RE: SSD 5765 ENVIRONMENTAL IMPACT STATEMENT

Thank you for providing Mid-Western Regional Council (Council) with the opportunity to provide input into the proposed Bowdens Silver Project. Council has reviewed the Environmental Impact Assessment (EIS) and wishes to provide the following comments for consideration.

2.2.2 Pipeline Design

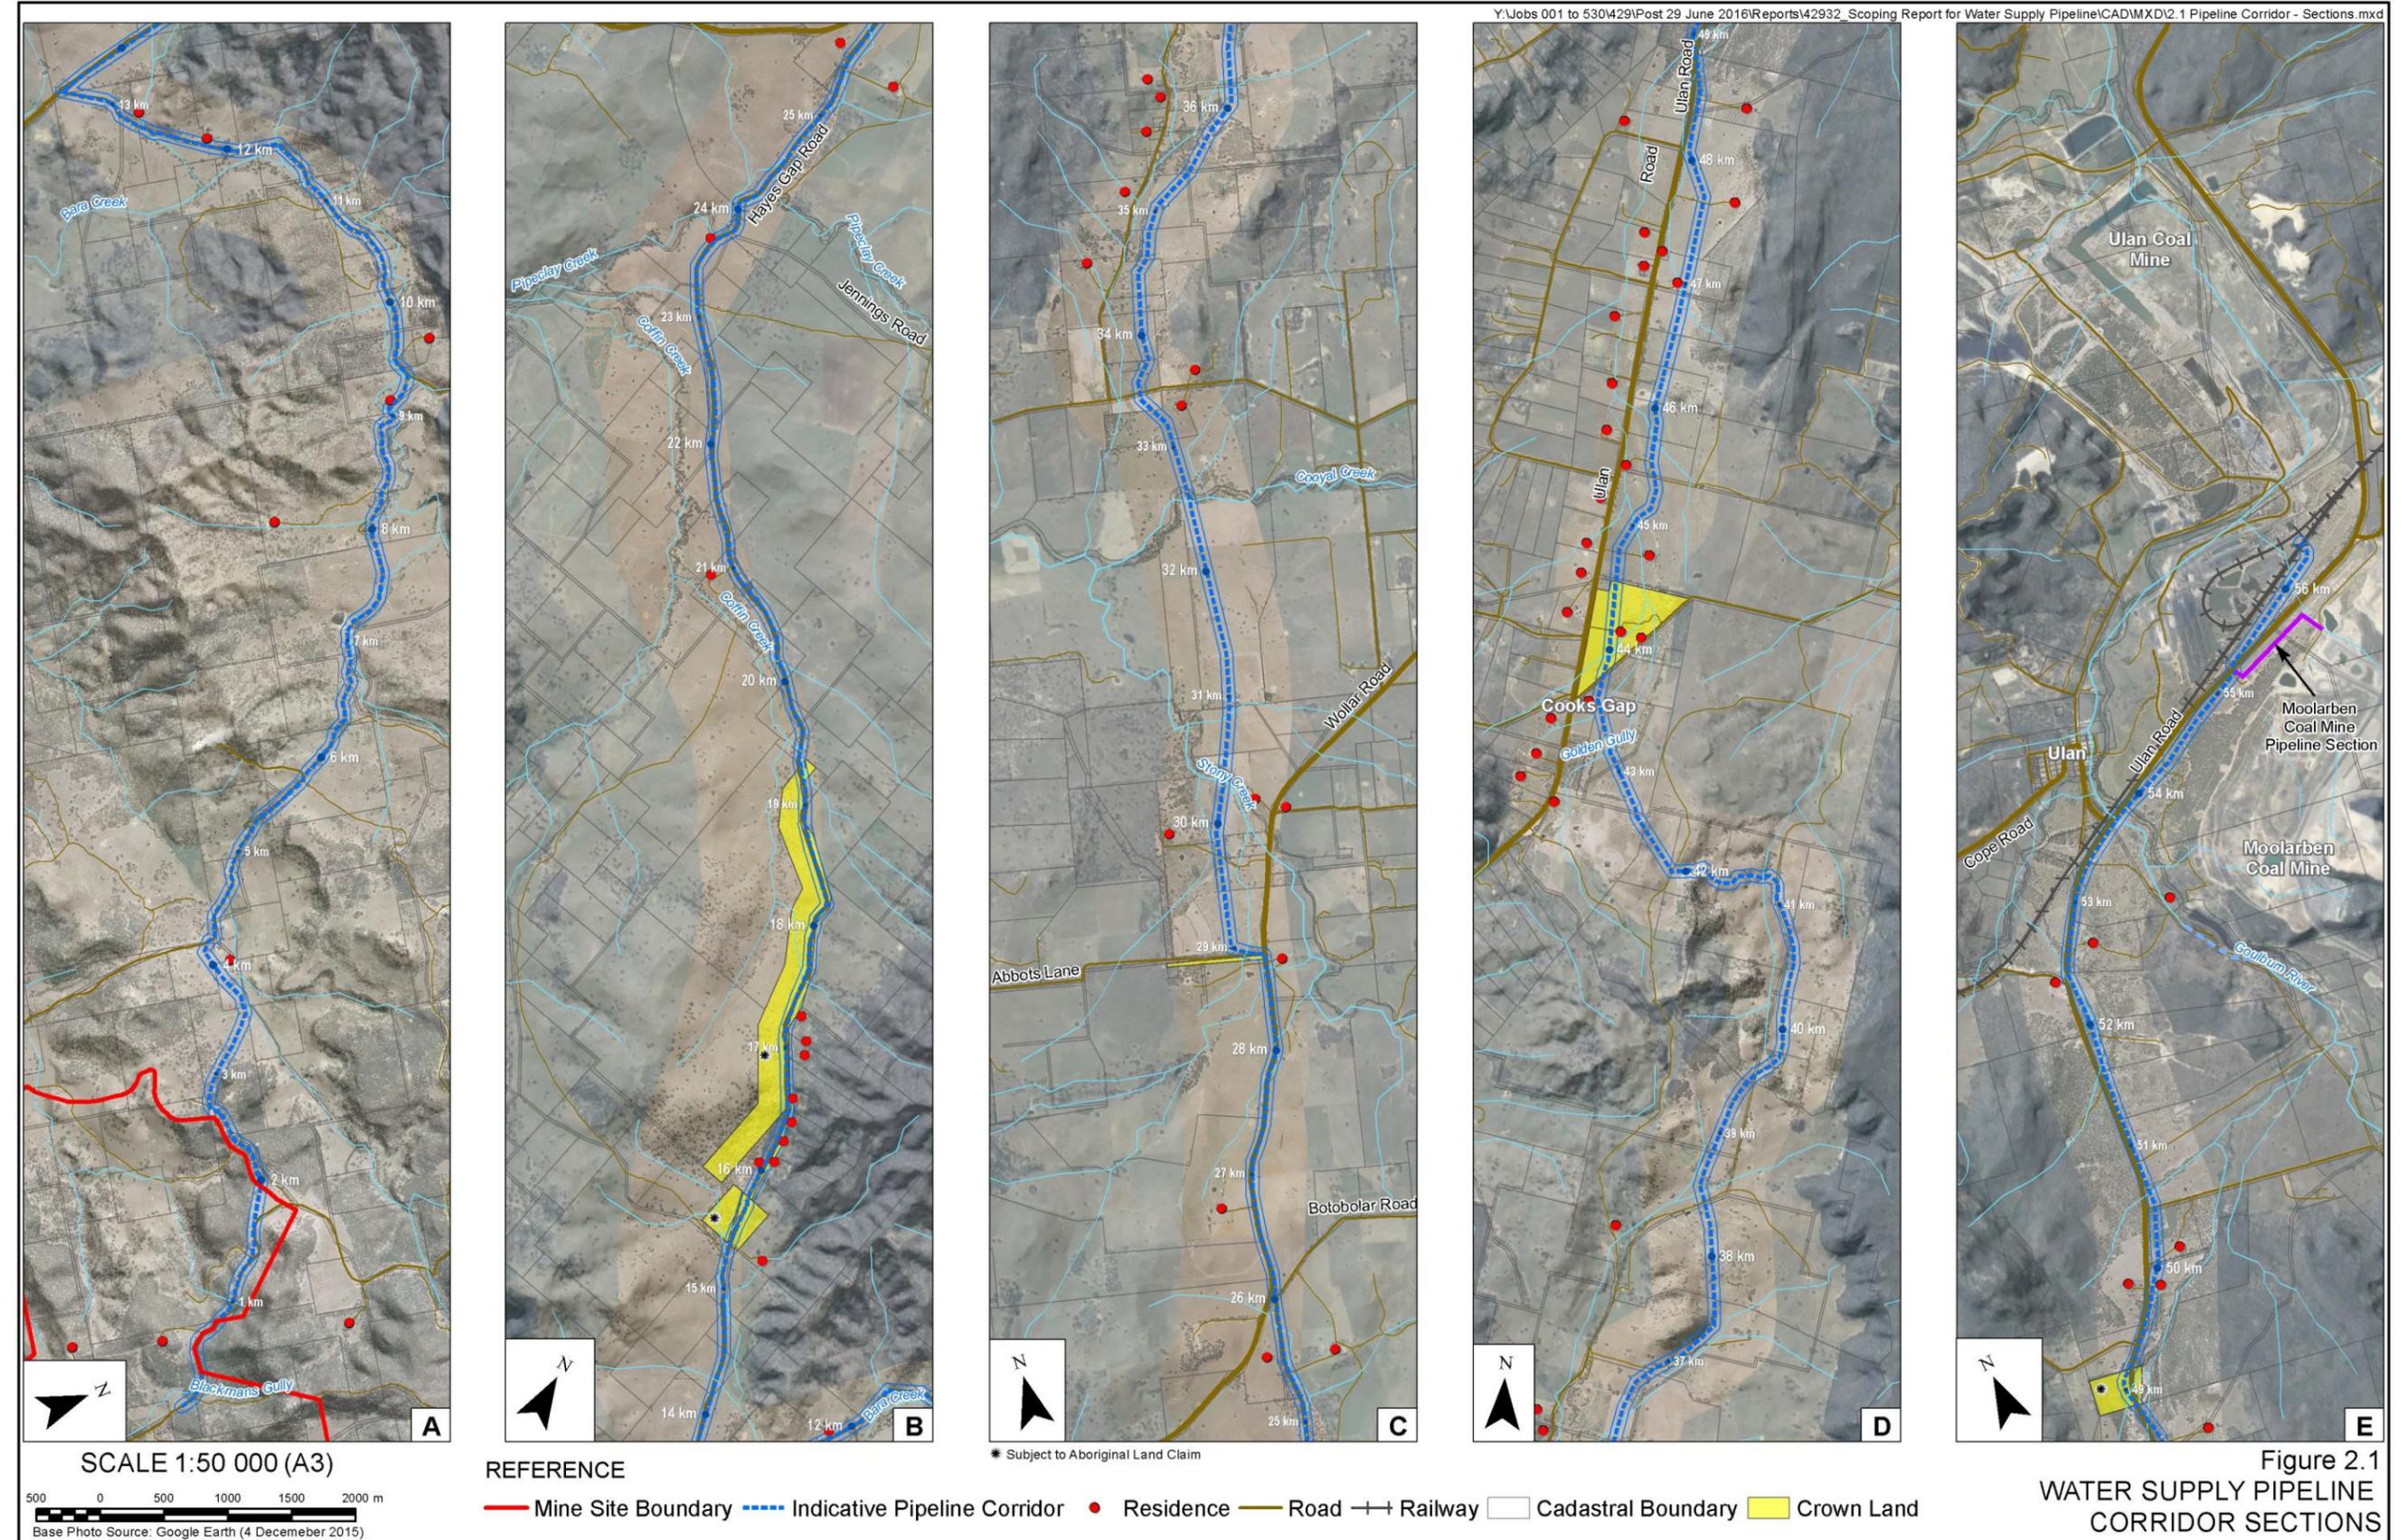
The scoping report for water supply indicates that the width of the pipeline corridor would be 12 – 15 metres wide. At this width, it would mean that the majority of any road reserve would be occupied by what is essentially a private water pipe. Further consideration of how this will impact the ability of Council to maintain its existing road infrastructure and undertake future activities within the road reserve is required. Alternatively, consideration should be given to locating the pipeline outside the road reserve as much as possible, particularly along Ulan Road.
